# KITTITAS COUNTY FIRE MARSHAL'S OFFICE

May 27, 2016

Re: McElliott (SP-16-00002)

# McELLIOTT AGRICULTURAL SHORT PLAT PART OF SECTION 20, T. 18 N., R. 19 E., W.M. KITTITAS COUNTY, WASHINGTON

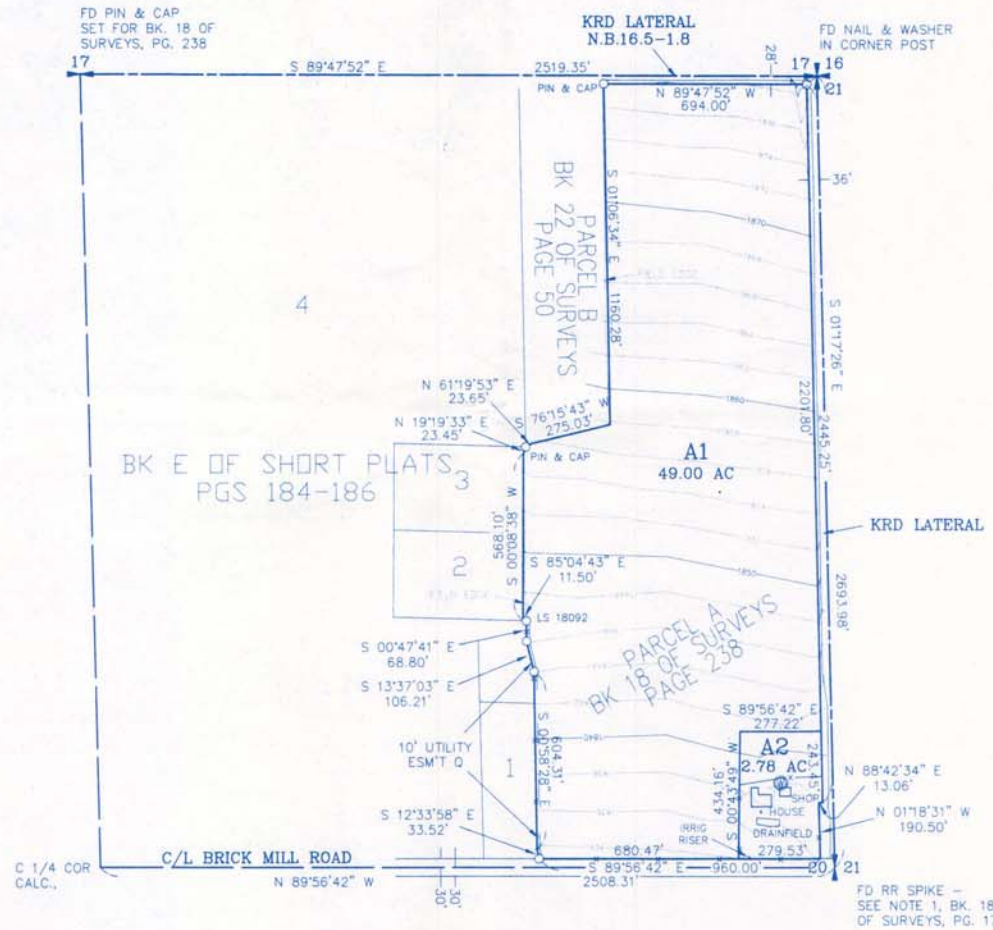
- The driveway(s) for the new property must comply with Kittitas County Code, i.e. any driveway greater in length than 150' shall be no less than 16 feet in width.
- The addresses shall be posted at the front of the property and easily visible from the road to emergency responders.
- Any new structures or substantial development to existing structures will require compliance with the Wildland Urban Interface Code.
- All future development must comply with the International Fire Code.
